## Appeal Decision

**Appeal Ref: APP/R5510/Z/23/3324217**

**Axis House, 242 Bath Road, Hillingdon, Heathrow UB3 5AY**

- The appeal is made under Regulation 17 of the Town and Country Planning (Control of Advertisements) (England) Regulations 2007 against a refusal to grant express consent.
- The appeal is made by ARM Capital against the decision of the Council of the London Borough of Hillingdon.
- The application Ref 43794/APP/2023/593, dated 28 February 2023, was refused by notice dated 24 April 2023.
- The advertisement proposed is described as "Installation of 1 x internally illuminated digital LED billboard".

Proposed elevations

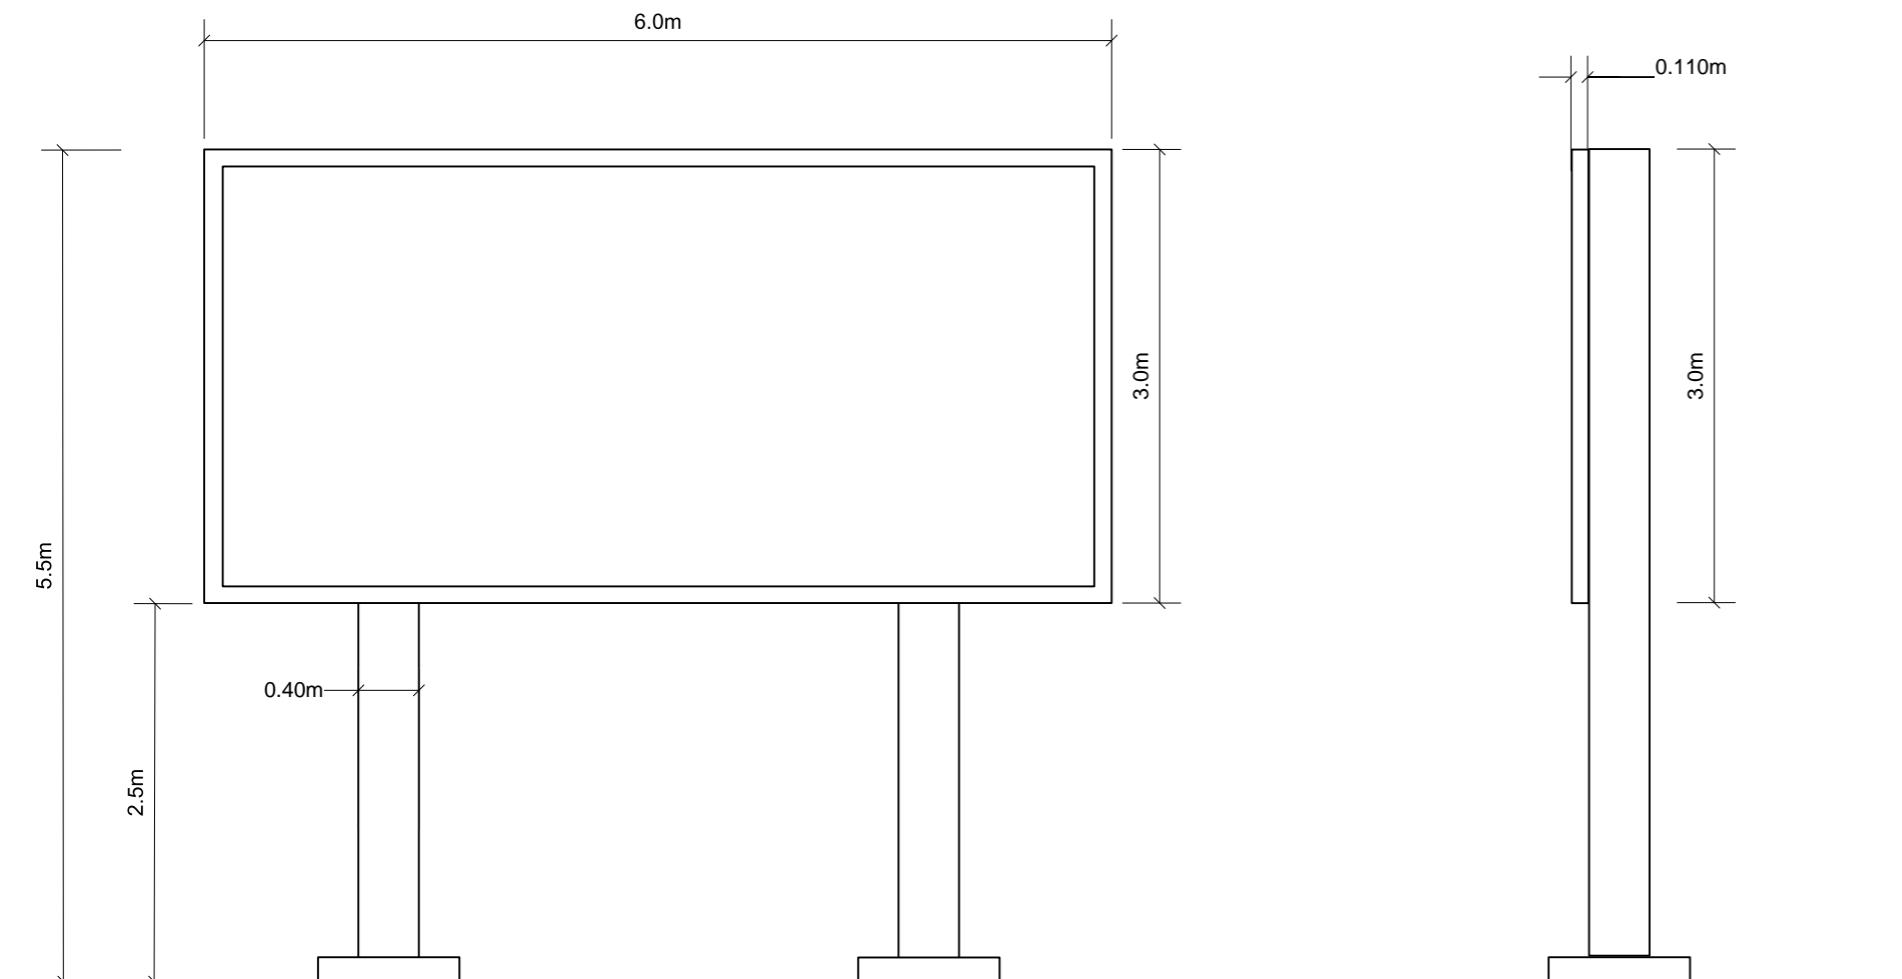
9. The proposed advertisement would be for a single internally illuminated digital billboard, situated in front of Axis House and set back from the highway. The proposal would be considerably elevated next to the highway and would, primarily, face highway users heading west on Bath Road and north on Bolton's Way. Where the advertisement would be positioned is currently a small, landscaped area, which softens the corner and where Axis House meets the highway. This small greenspace contributes positively to the street scene and to the area's amenity.

10. The proposed positioning of the advertisement would reduce the current space between Axis House and the highway, resulting in a visually cramped, cluttered corner and limiting the visual appearance of the soft landscaping. Furthermore, I find the illumination aspect of the advertisement, when coupled with the proposed sizing, would be incongruous in the locality. Whilst the area is primarily commercial, within the immediate vicinity there is no similar advertisement with a comparable surface size or setting. Of the advertisements nearby and located near the highway, they are generally smaller than the proposal in question. Therefore, by reason of its size, scale and positioning the advertisement would appear as an overly conspicuous and dominant visual feature which the appeal site could not comfortably accommodate, culminating in harm to the street scene and to the amenity of the area.

11. The appellant has drawn my attention to the fact that the proposed advertisement would include a light sensor to automatically reduce illumination to make it resemble a traditional paper billboard. However, this would not overcome the harm caused by the excessive scale of the proposal and its undue prominence within the street scene, and therefore very limited weight is afforded to this consideration.
